DOC20/490839-9; EF 14/25399 (SSD 9697)

**Bayswater Power Station Upgrade - (SSD 9697)- Environmental Impact Statement  
Review by the Environment Protection Authority**

## **ATTACHMENT A – EPA additional information requirements**

Figure 5.3: Coal Handling Plant water management system (Source AECOM, 2017)

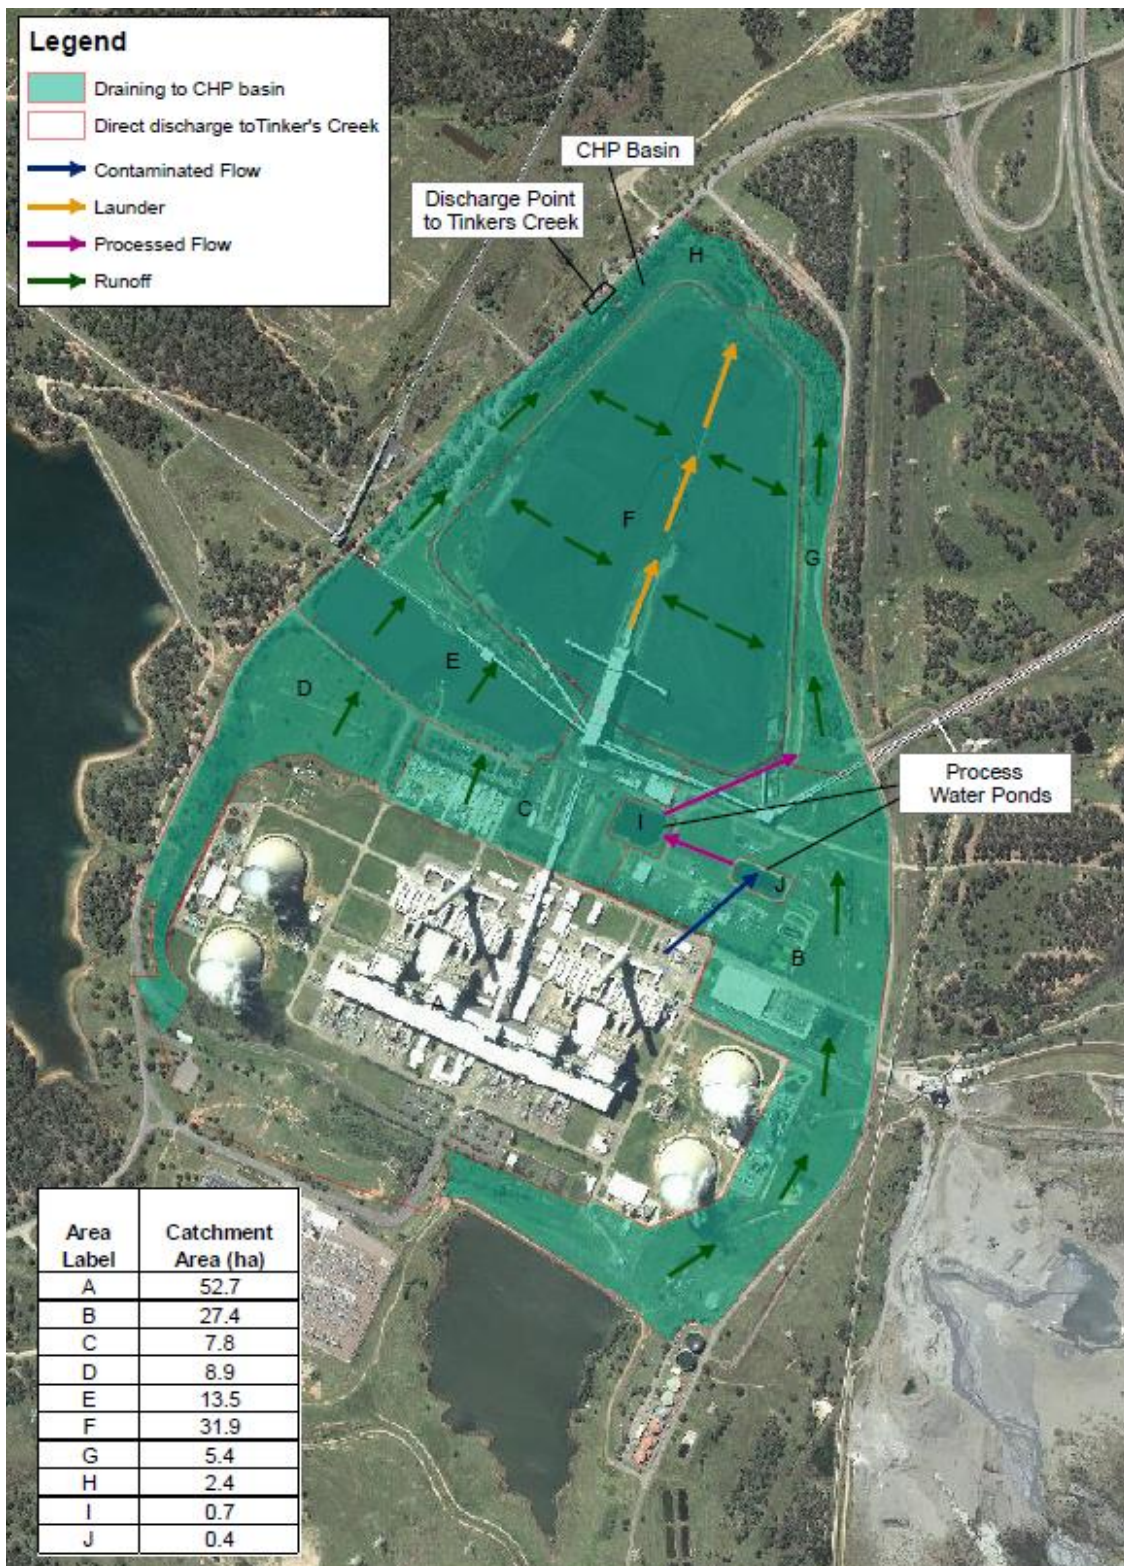
Substantial volumes of water discharge daily from the coal handling plant sediment basin. The EIS indicates that the proposal will involve upgrades to the coal handling plant water management system but predicts discharge volumes will remain unchanged. Details of the measures that will be implemented to minimise pollution and mitigate impacts to waterways from coal handling plant and an assessment of residual impacts are required.

Figure 6.4: Simulated Ash Dam pond water volume for existing conditions.

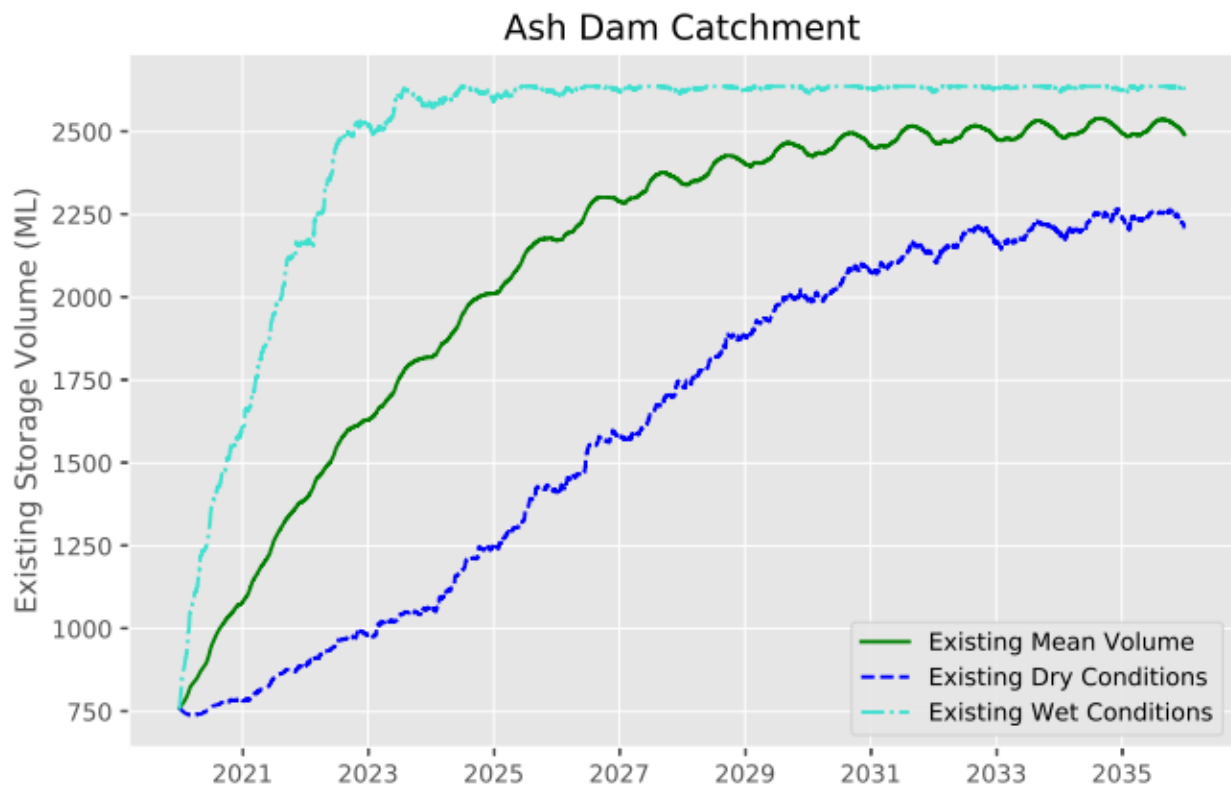
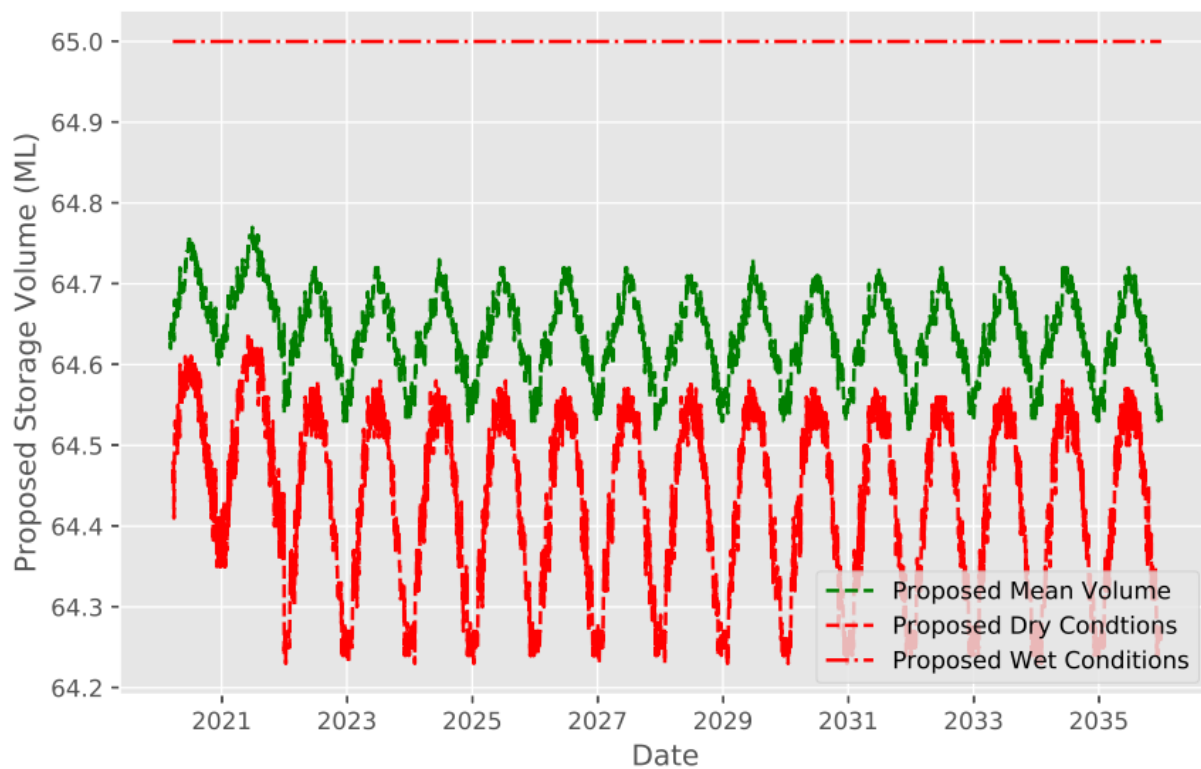
A review of the seepage rates adopted in the water balance model as presented in Table 6.3 of Appendix E should be provided with justification why seepage rates would decrease with increasing ash dam volume.

**Figure 5-3: Mapping of salt cake landfill area overlaid with 1 m contour lines (Source: Jacobs 2019)**

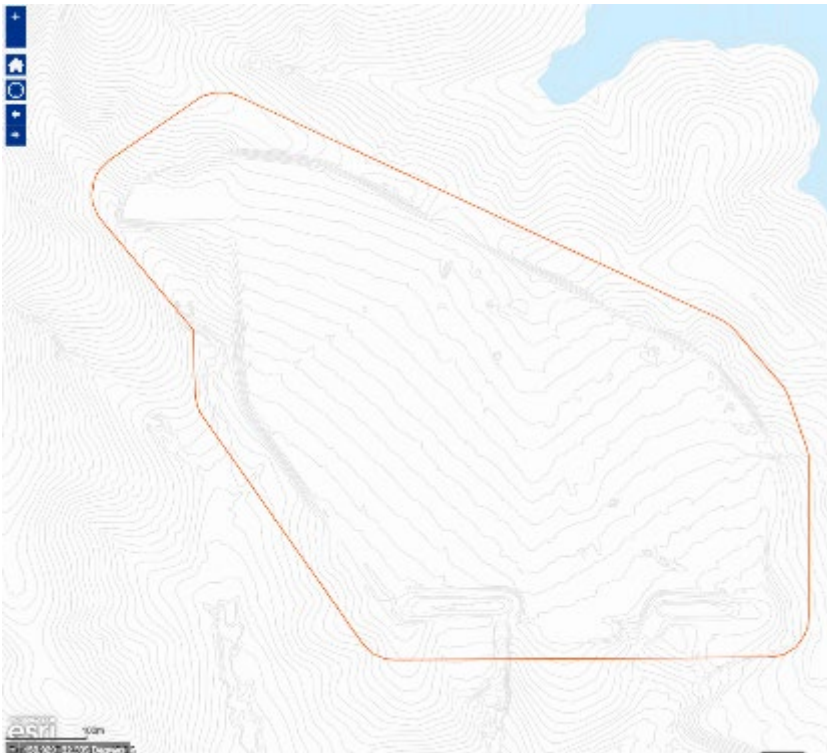
The salt cake landfill specifications conceptually meet the requirements of the *NSW EPA Environmental Guidelines Solid waste landfills, second edition, 2016* (the Landfill Guidelines). Detailed technical drawings are required to confirm compliance with the Landfill Guidelines including that the liner specifications are compatible with the brine leachate.
